24/09/2021

**New Primary School at Edmondson Park (SSD-10224)
Request for additional information**

I refer to the abovementioned application for the New Primary School at Edmondson Park (SSD-10224) and the Response to Submissions (RtS) provided.

Drawing Title
SITE PLAN

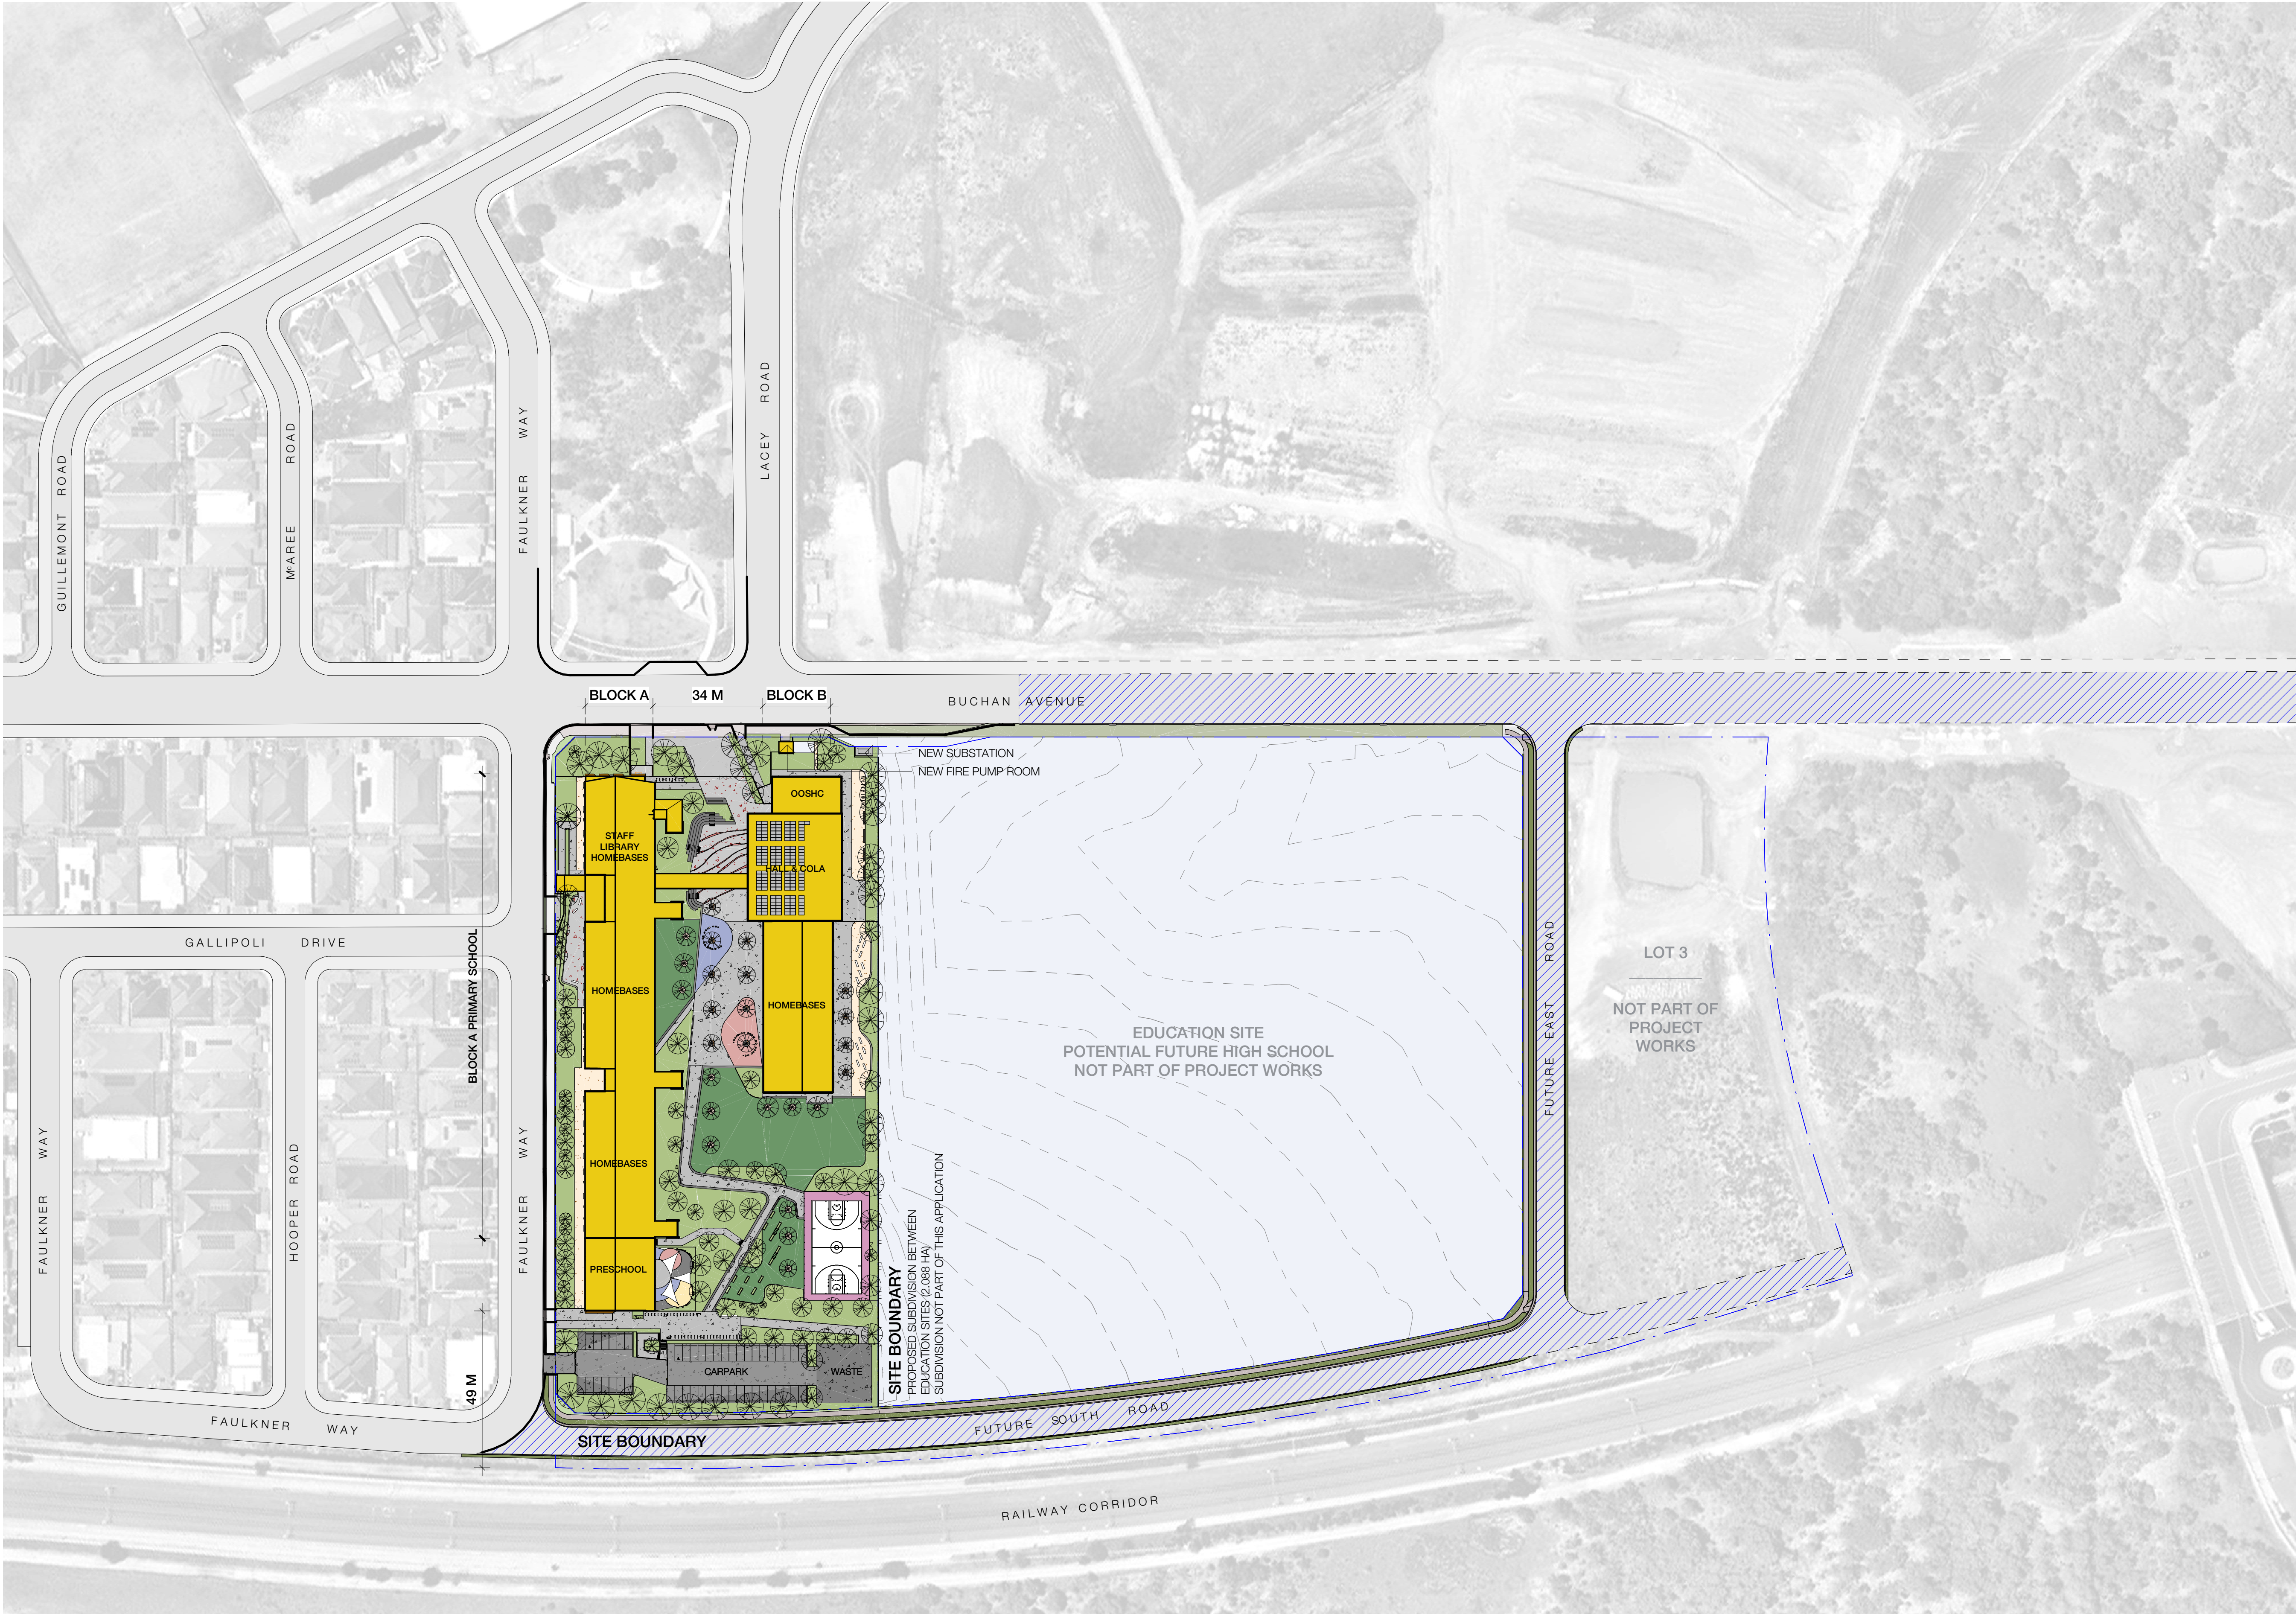
- clarification regarding the location of construction access, waste storage and construction worker parking on Lot 2, and whether this is included as part of the identified site area associated with the proposal. Updated documents should be provided if the site area is to be expanded.
